Re: Foundation Evaluation
155 Mockingbird Lane
Spring Lake, North Carolina

OTG Consulting, PLLC (OTG) was requested to visit the subject site above to observe the CMU piers and footings for the property at 155 Mockingbird Lane. We understand that the building inspector had failed the foundation due to several piers that appeared not to be located within the middle third of the footing. Mr. Scott G. Dowell, P.E. was onsite on February 22, 2021 to evaluate the CMU piers and their location on the footings. Upon arrival, Mr. Roberts had already numbered the piers to allow for easier identification.

PROPOSED  
RESIDENCE  
FOR  
ANDREW & ANITA  
RUHLAND  
155 MOCKINGBIRD LANE  
SPRING LAKE, NC 28390

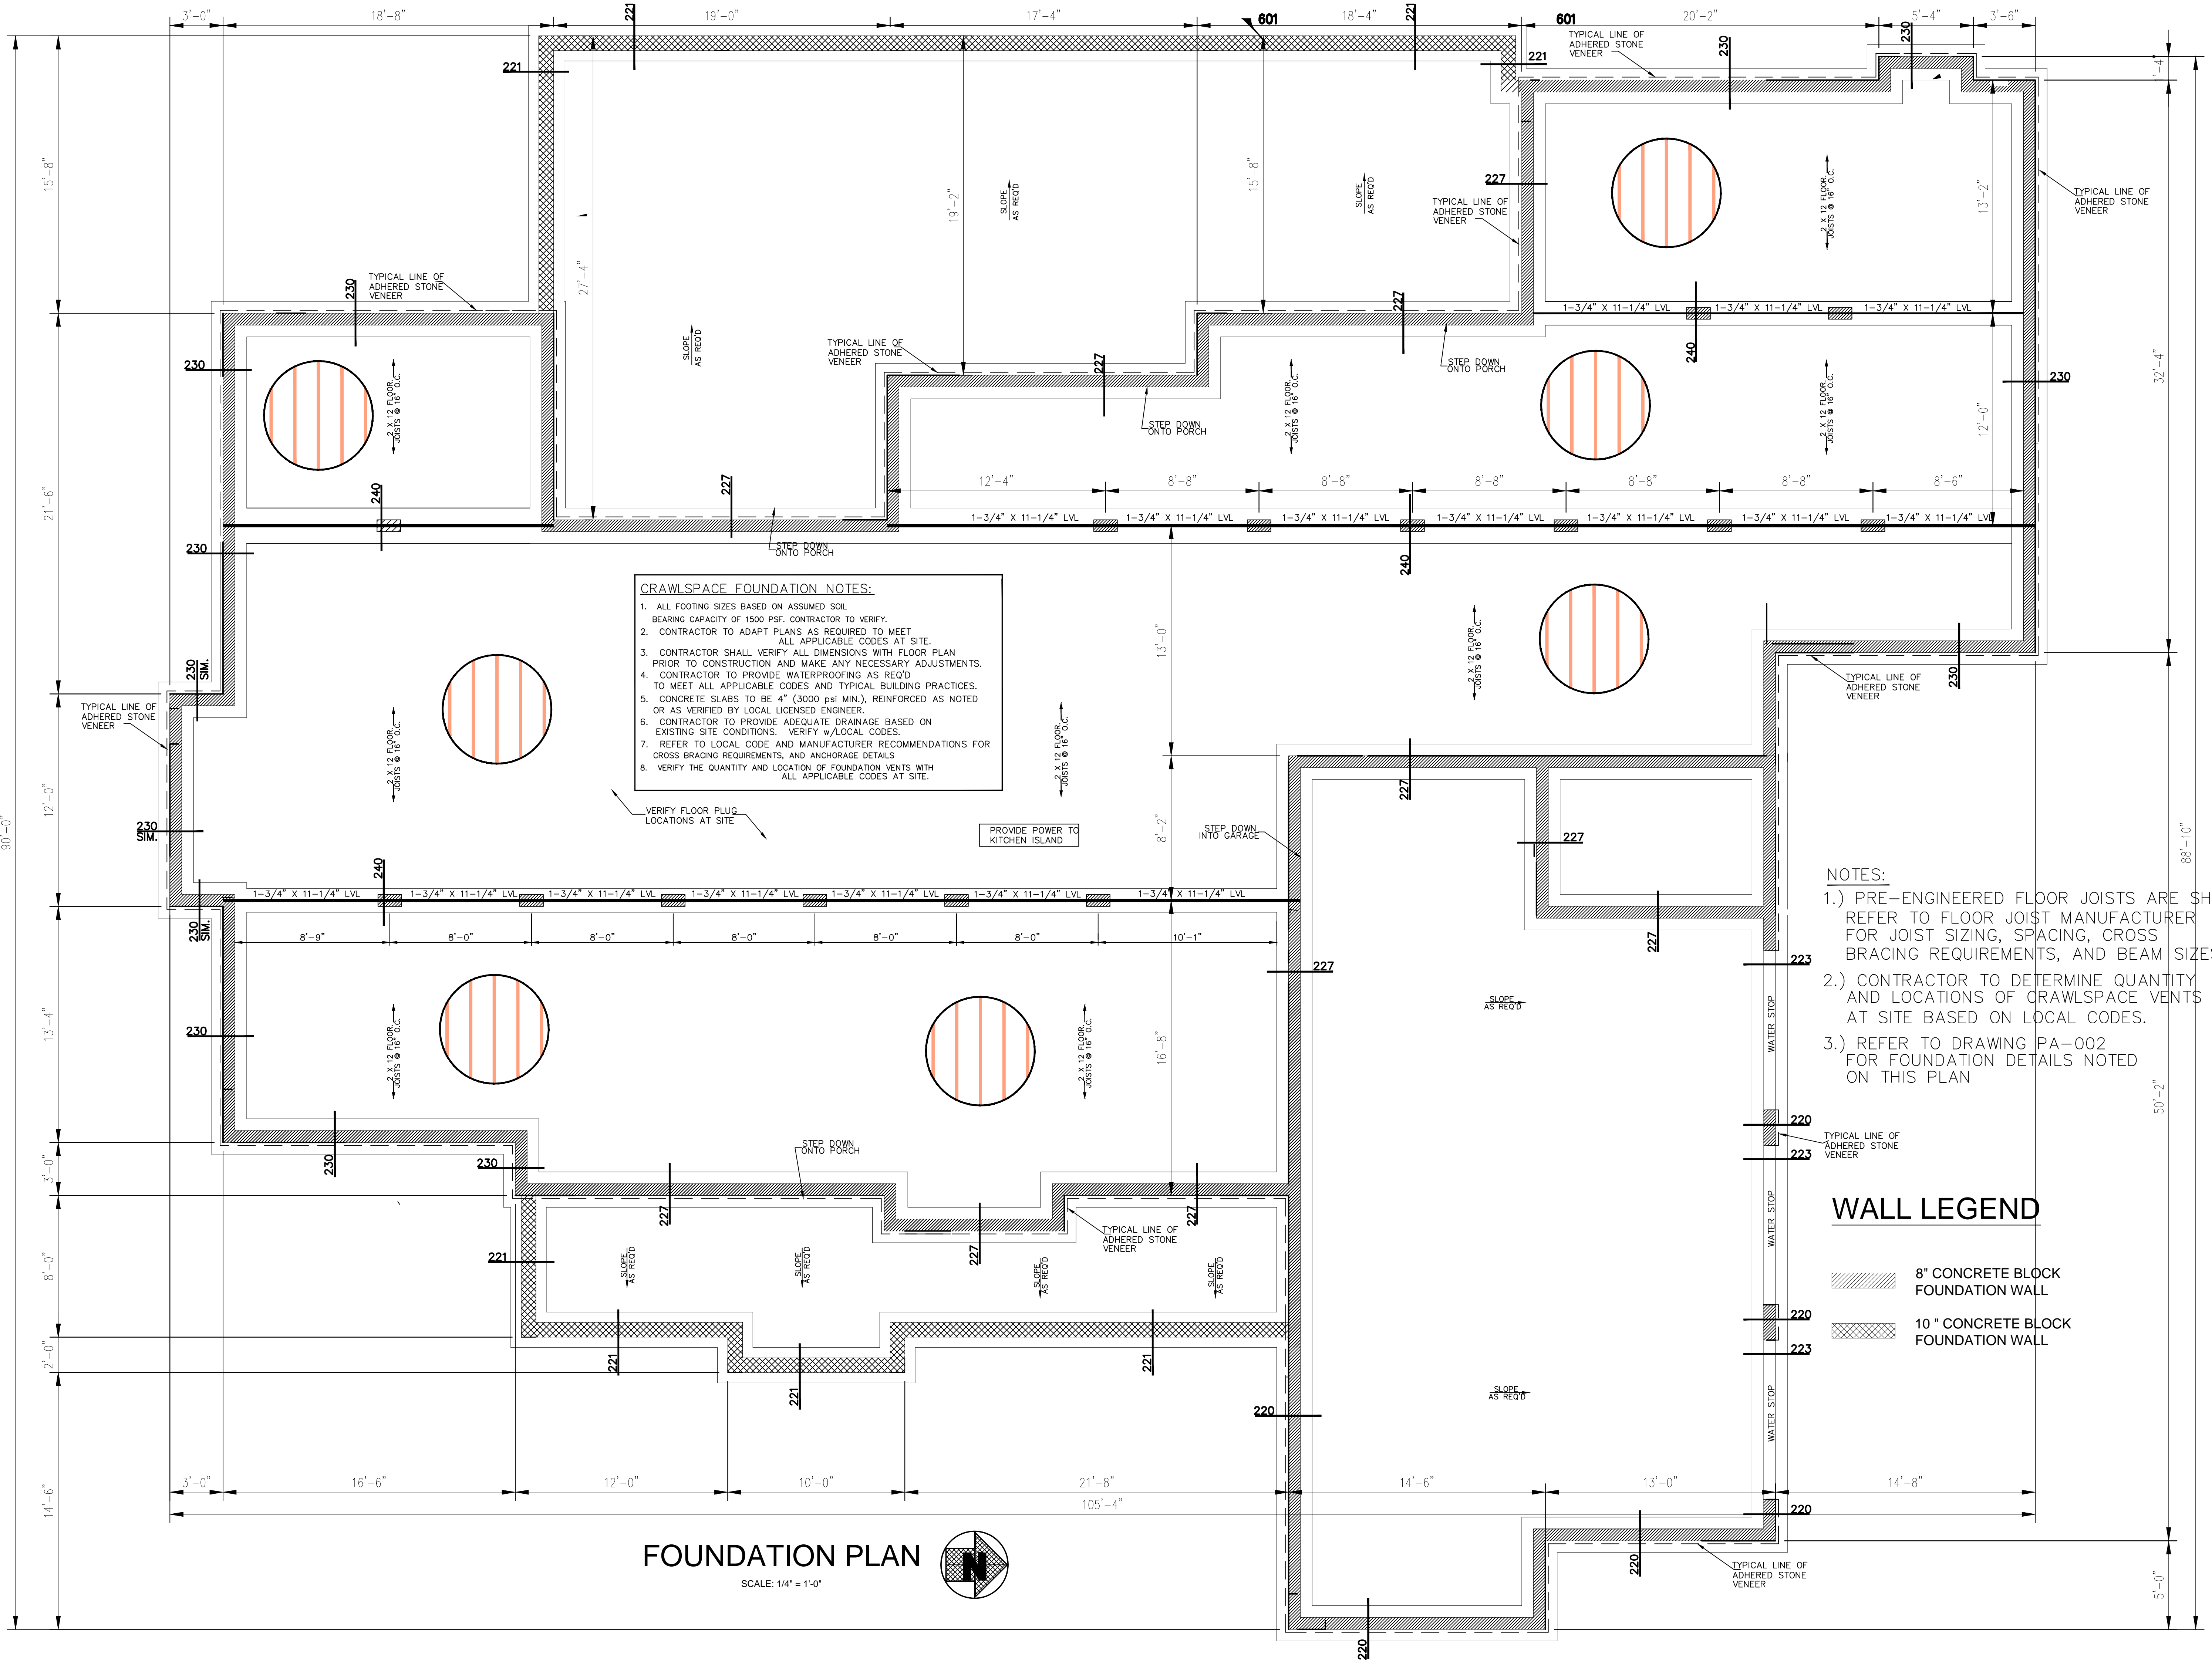
The piers of concern were 1, 2, 10, 22, and 23. Per the 2018 NC Residential Building Code, Table R403.1(2) Pier and Footing Sizes for Support of Girders, footnote c, “Centers of piers shall bear in the middle 1/3 of the footing.” OTG reviewed the piers, as well as the ones in question. Piers 1, 2, 22, and 23 did not meet this requirement and the contractor had doweled into the footing to extend and allow for proper support. OTG verified the dowel placement and that the additional concrete would allow for the center of the pier to bear within the middle 1/3. The remaining piers met this requirement, and the eccentricity in loading will not impact the support of the girders or lead to excess bearing pressures beneath the footing.
